Proposed balcony extension above existing sun room with screening to east elevation.

2 The Strand Ferring

Thank you for your internet representation made on 15th December 2013 which has been recorded as '**an objection**' with the comments as follows:

Proposed rear elevation. Scale 1:100

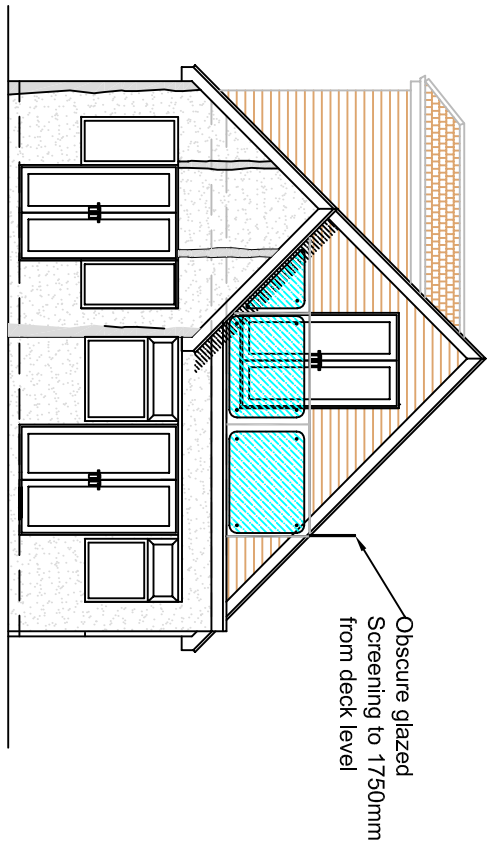
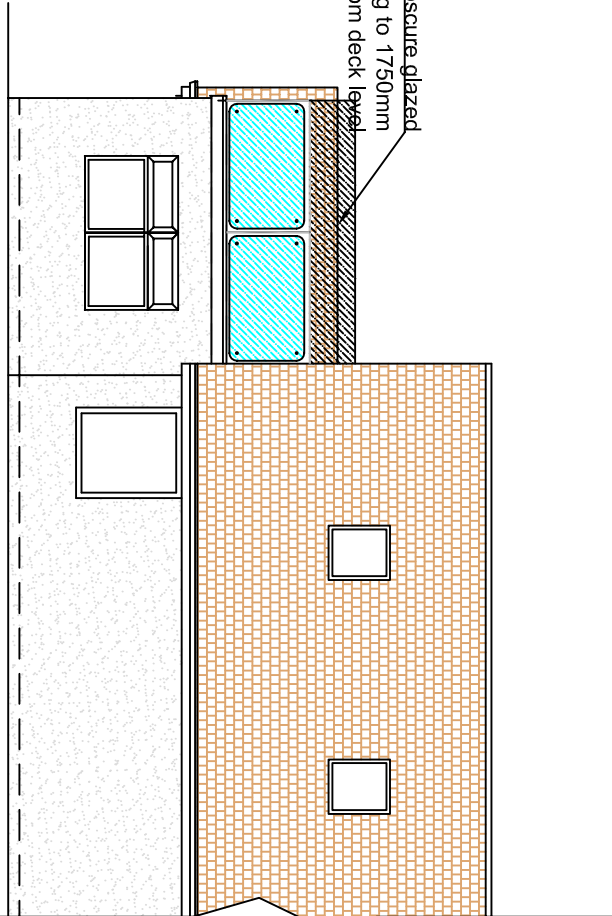
- 1. The actual height increase to the conservatory roof is much more substantial than indicated and will result in significant loss of daylight in to our kitchen/diner.*
- 2. It will invade our privacy to the immediate rear of our property as well as approx 90% of our garden, not to mention no.3's garden.*
- 3. The design is adhoc, modern in appearance and in our opinion, not in keeping with the property like a juliette balcony would be.*
- 4. Regards point 10 on the application, we wish to point out that the rear of the property, and therefore balcony, is visible from the access lane to the beach car park, the car park itself, the public footpath that runs past number 3 as well as the beach area.*
